Comments on the amended plans for planning application **2021/62/93013**, which now appears to be for the erection of a single storey side, single storey rear, rear dormer extension, and demolition of the existing garage at 74 Cleveland Road, Marsh HD1 4PW.

Proposed Elevation 1:100 @ A1

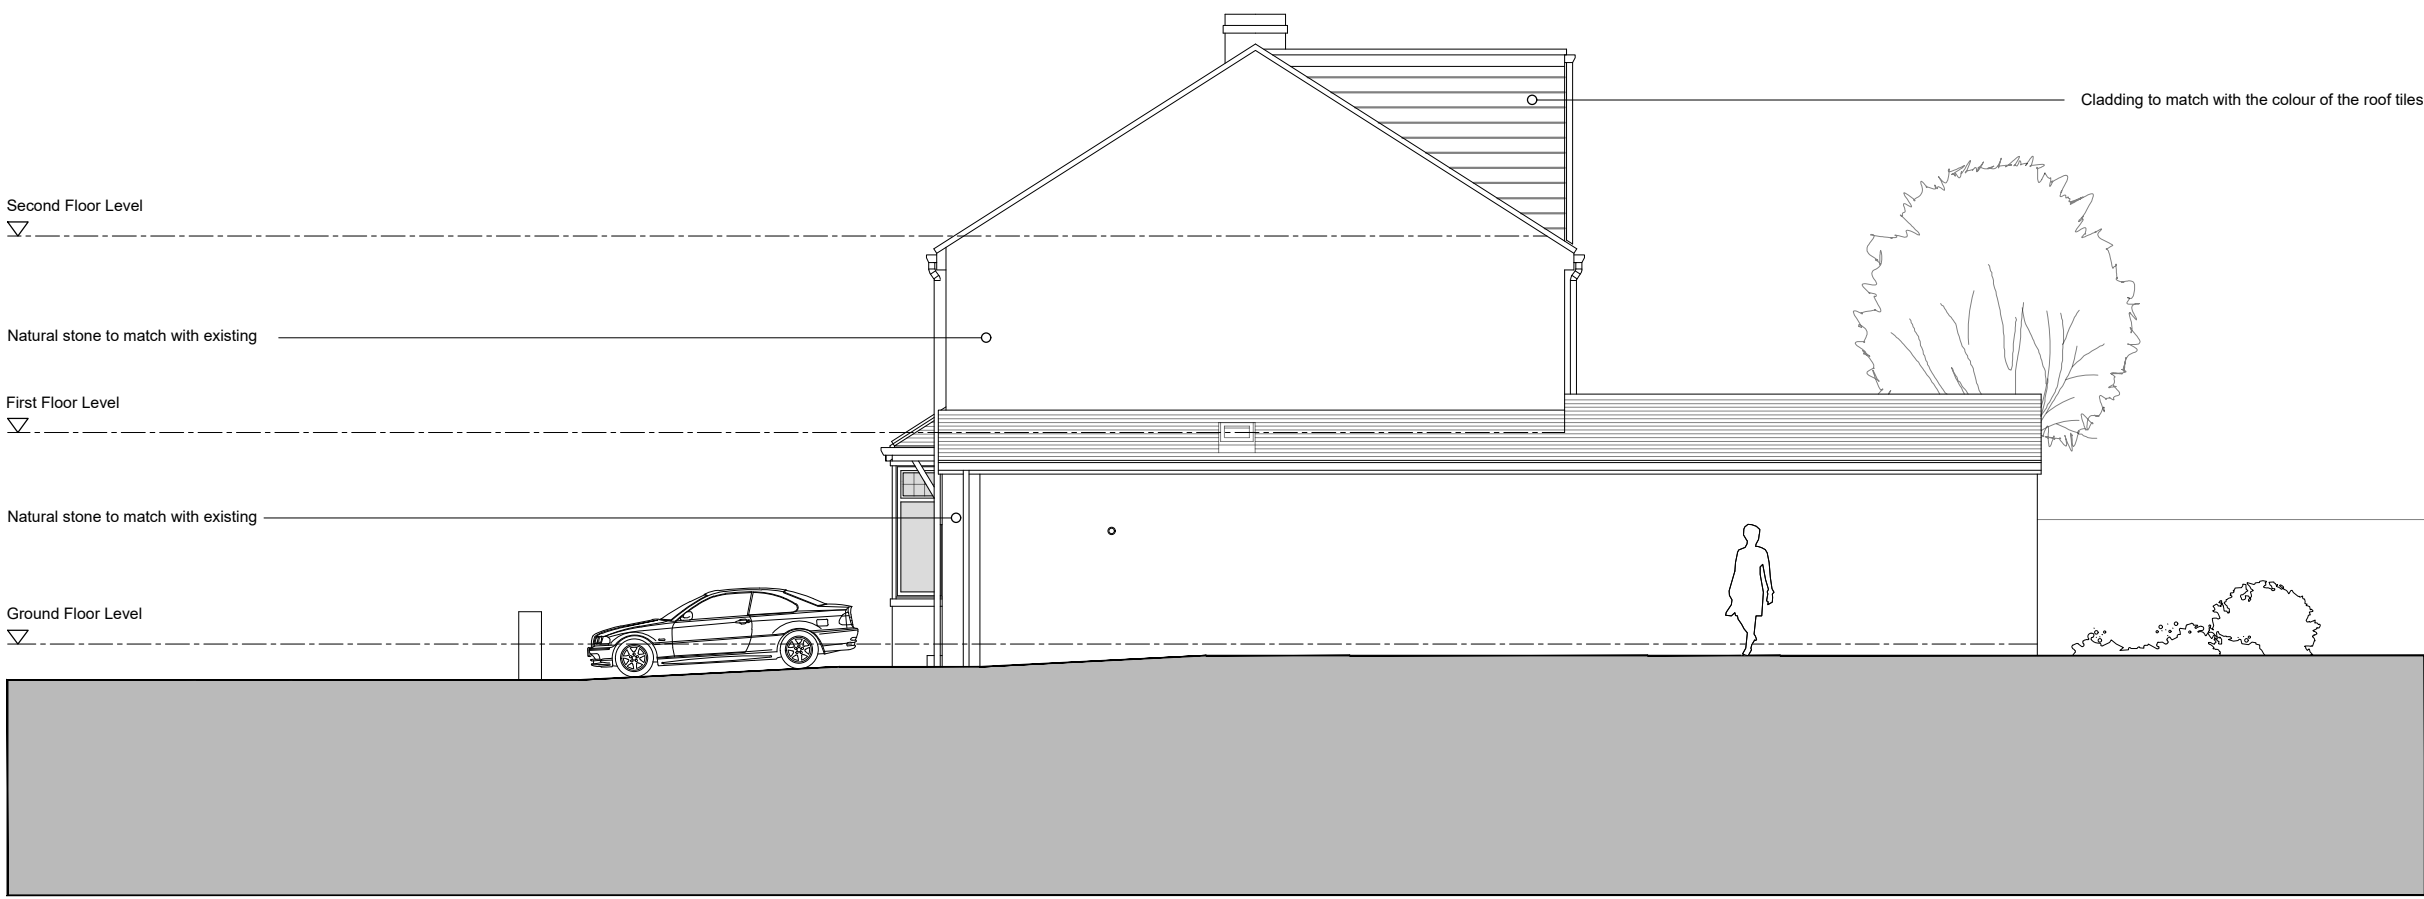
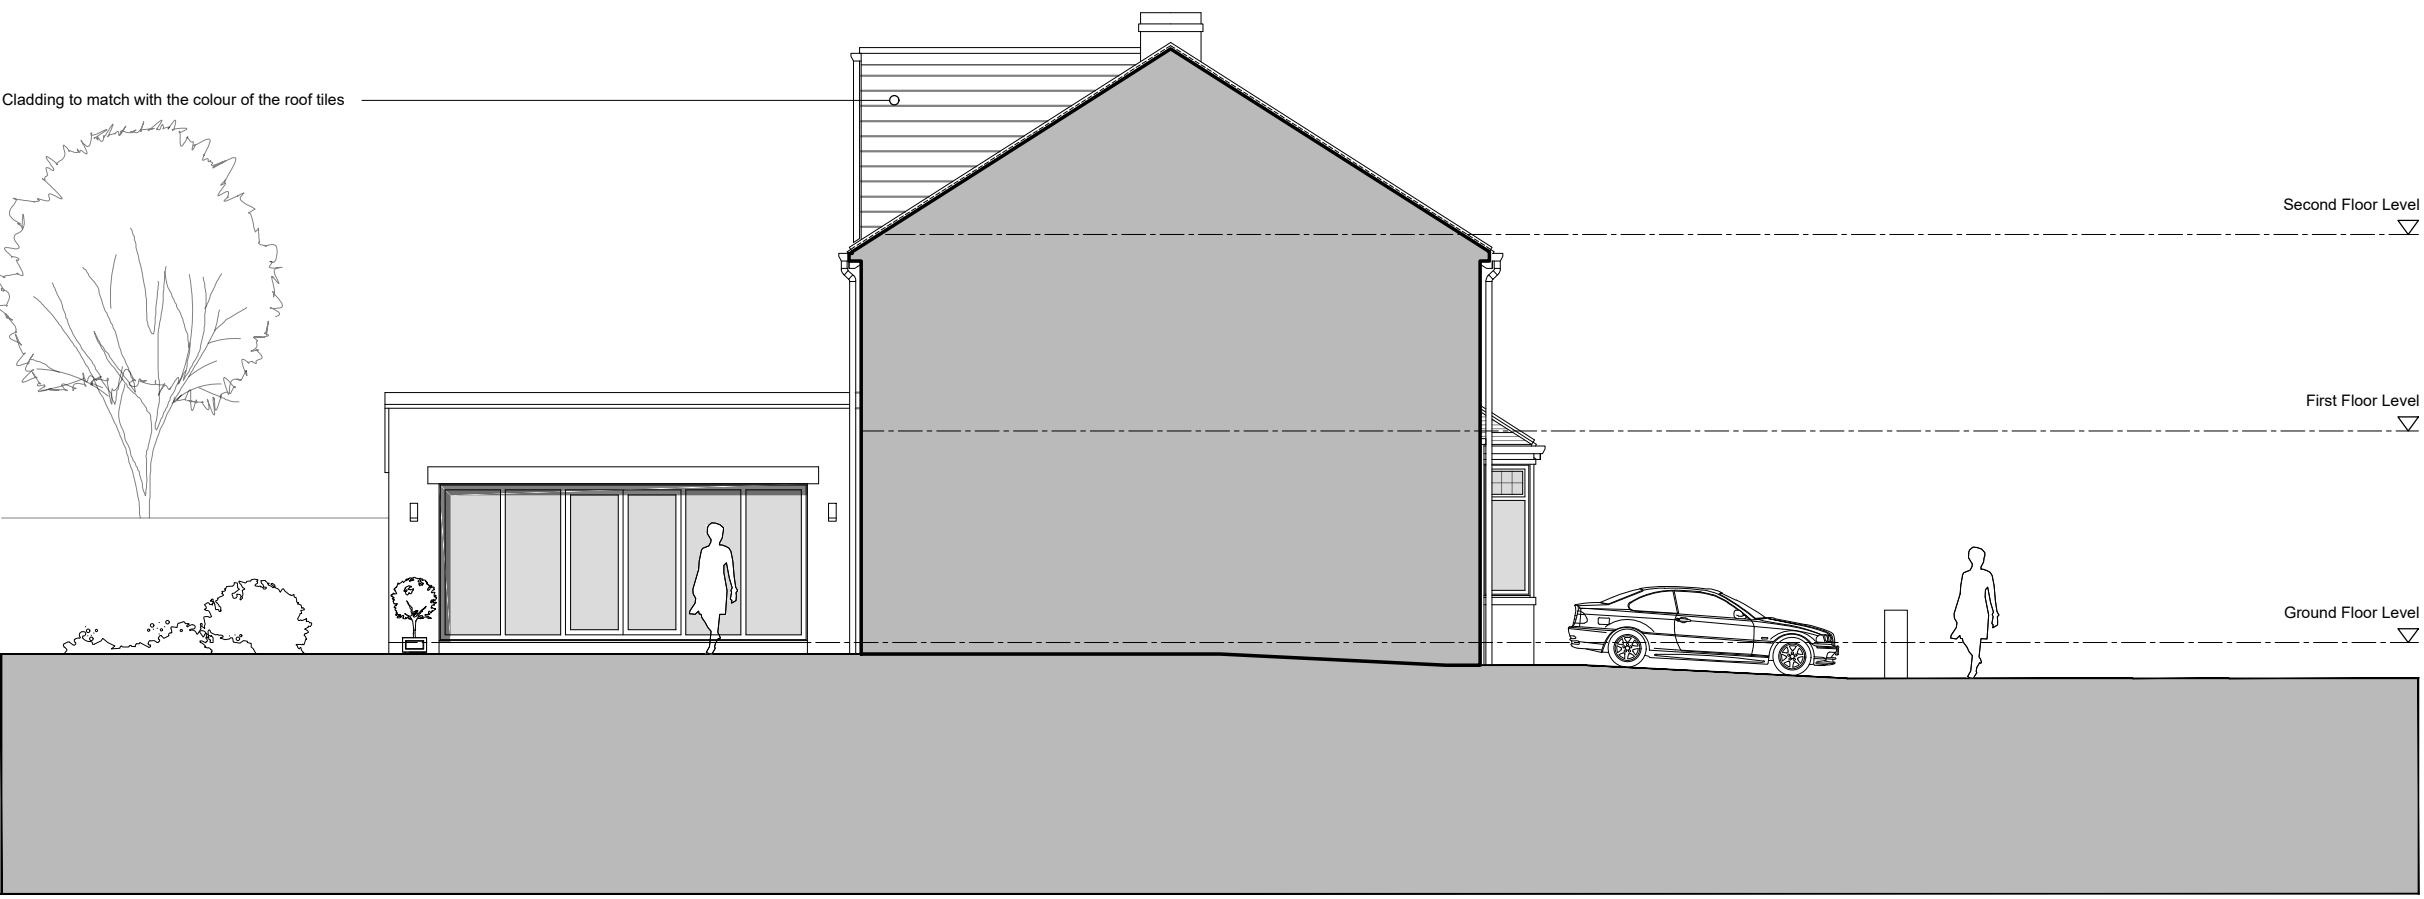
Having looked at the amended plans available online, it seems to me that the proposed development still represents a significant extension of the existing property in terms of its scale, bulk and mass when viewed in context with the footprint of the plot size and the closely spaced existing residential properties to the rear and side, which still does not comply with the objectives of Kirklees Council's Local Plan Policy LP24 (Design).

I appreciate that the scheme has been amended so that the side extension will be reduced in height but clearly the extensions of the existing property when viewed together remain very large in scale compared to the existing plot size. In particular, the proposed rear extension will extend the entire distance to the rear of the plot, which meets the boundary line of my property. Similarly, the side extension will extend the full width of the plot to the boundary line of my property where there is an access path thus creating an extremely blank and stark facade from my rear garden. Policy LP24 does not support the scope for such extensions to residential properties and the resulting impact that they can have so I remain unable to see how the proposed extension can comply with Policy LP24 and therefore should not be granted planning permission.
